KITTITAS COUNTY

DEPARTMENT OF PUBLIC WORKS

MEMORANDUM

TO: All Staff
FROM: Public Works Plan Review Team
DATE: October 17, 2024
SUBJECT: SP-24-00013 McIntosh

McINTOSH SHORT PLAT PART OF SECTION 8, T. 18 N., R. 18 E., W.M. KITTITAS COUNTY, WASHINGTON

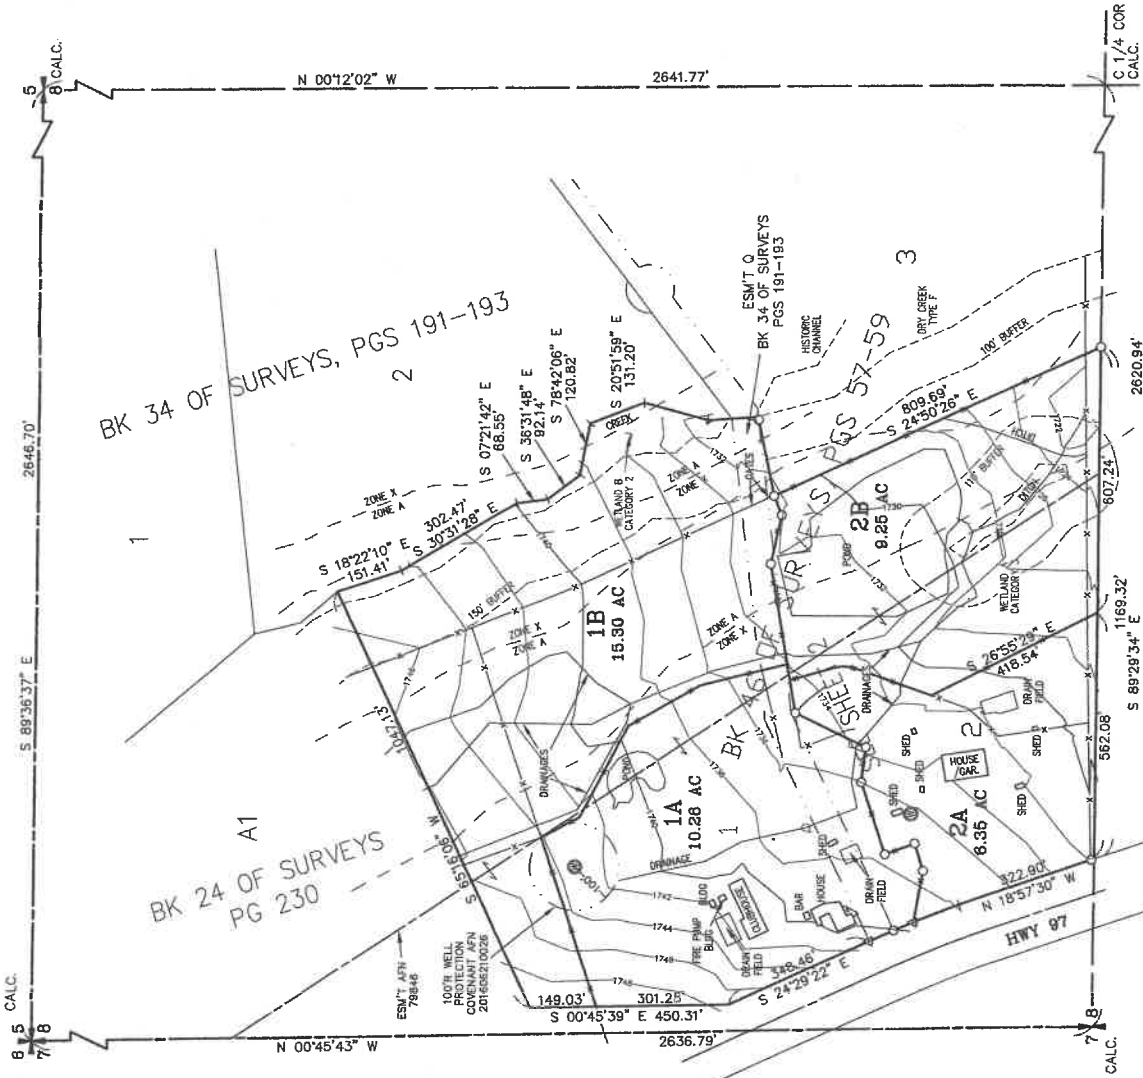
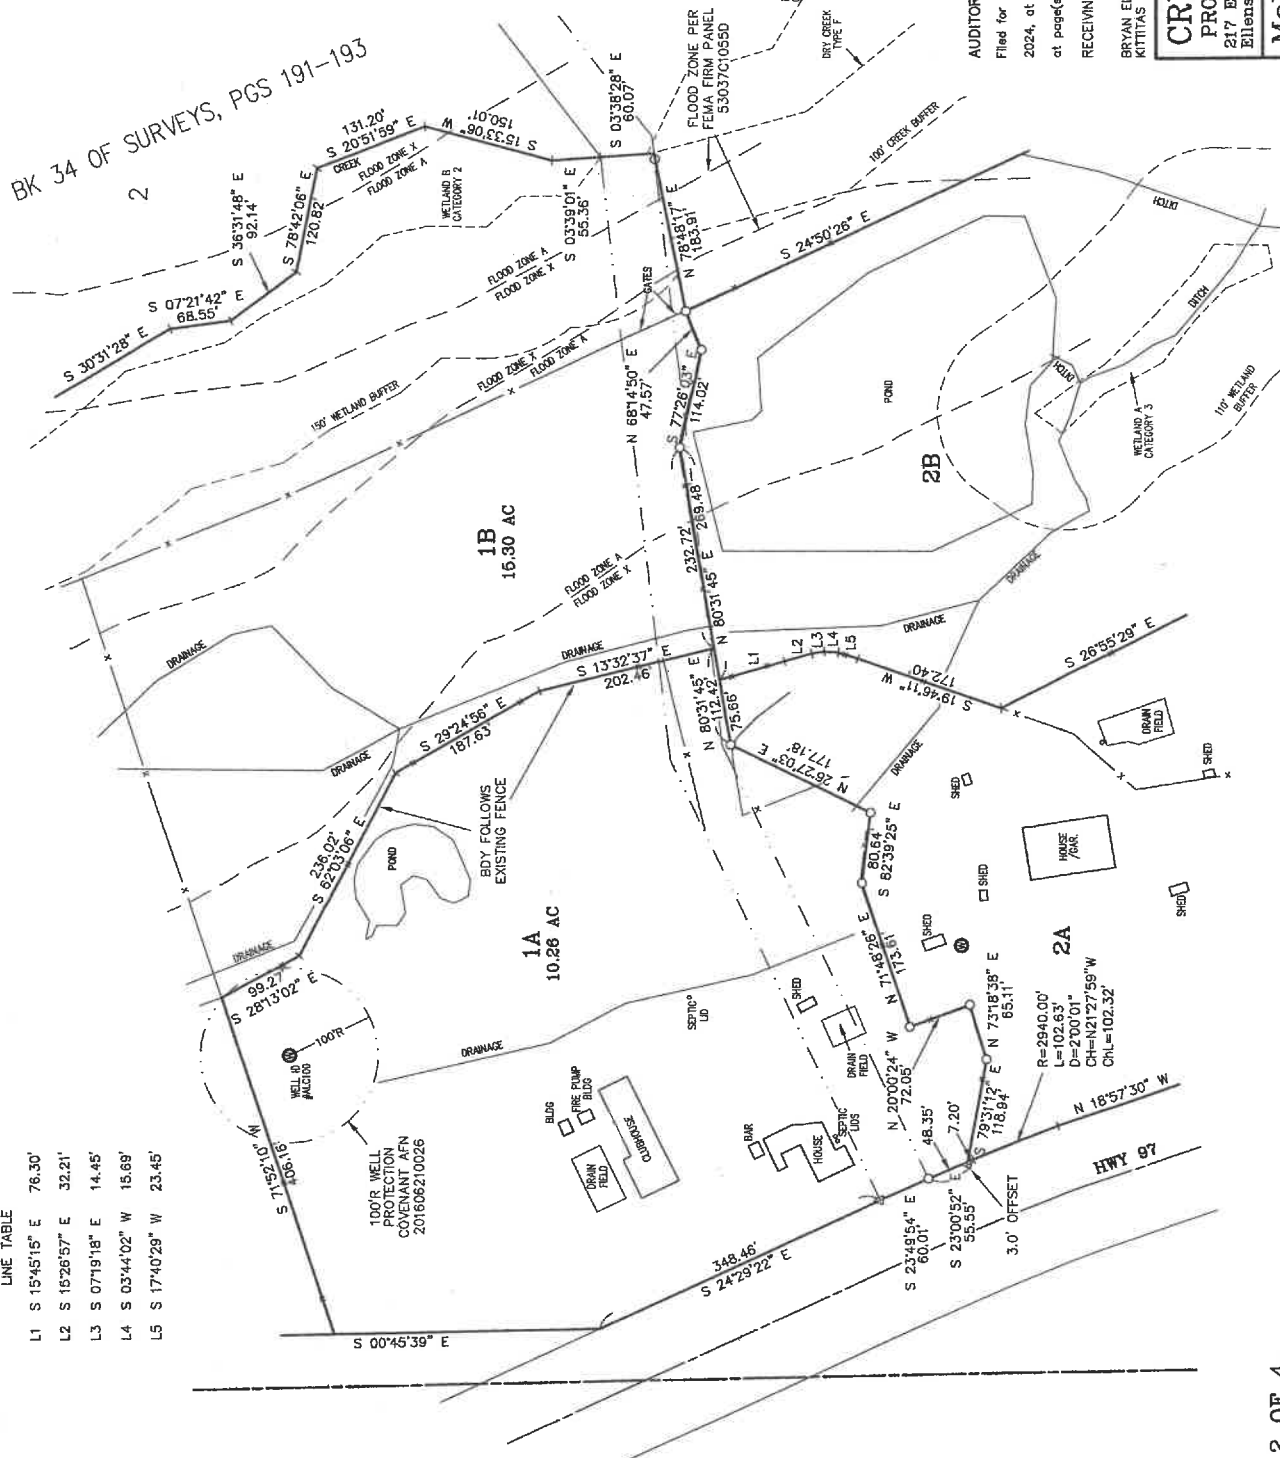
ACCESS	<ol style="list-style-type: none">1. An approved access permit shall be required from the Kittitas County Department of Public Works prior to creating any new driveway access or altering an existing access.2. KCC allows up to 4 lots on a joint-use driveway. Additional lots utilizing easement Q may trigger private road standards and requirements (road naming and road certification).3. An access permit from WSDOT may be required.4. Maintenance of driveway approaches shall be the responsibility of the owner whose property they serve. The County will not maintain accesses.5. Any further subdivision or lots to be served by proposed access may result in further access requirements. See Kittitas County Road Standards.6. In addition to the above-mentioned conditions, all applicable Kittitas County Road Standards apply to this proposal. Access is not guaranteed to any existing or created parcel on this application. <p>OF NOTE: Easement Q has a drain field and shed located in access easement. Relocation of easement Q may be required. (JS)</p>

SURVEY	Verify equipment used. Page one says GPS for contours, page 3 calls out a total station. Missing basis of bearings. SR97 needs to call out ownership and ROW width. Width for existing easement needs added. Missing Point of beginning of deed. Currently, there are 3 access driveways to proposed lot 2A. Not shown on existing survey (DF)
TRANSPORTATION CONCURRENCY	No transportation requirement for this project. (KAH)
FLOOD	<p>A portion of parcels #15102 and 866033 are within the FEMA identified special flood hazard area (100-year floodplain) zone A. If possible, any future development should occur outside of the floodplain in order to reduce risk and avoid mandatory flood insurance purchase requirements. All activities within the floodplain must be permitted through the floodplain development permit process and follow the regulations within KCC 14.08.</p> <p>In accordance with KCC Chapter 14.08.220, all subdivisions as well as new development shall:</p> <ol style="list-style-type: none">1. Be consistent with the need to minimize flood damage.2. Have public utilities and facilities such as sewer, gas, electrical, and water systems located and constructed to minimize flood damage.3. Have adequate drainage provided to reduce exposure to flood damage.4. Where base flood elevation data has not been provided or is not available from another authoritative source, it shall be generated for subdivision proposals and other proposed developments containing greater than 50 lots or 5 acres (whichever is lesser) and shall be included as part of the application and shall be noted on the final mylar.5. All subdivisions shall show on the face of both the preliminary and final plat, for either short or long plats, the boundary of the 100-year floodplain and floodway. <p>Since the parcels are located in zone A, KCC 14.08.220(4) is applicable. Please contact the Floodplain Administrator at 509-962-7523 for assistance. (SC)</p>
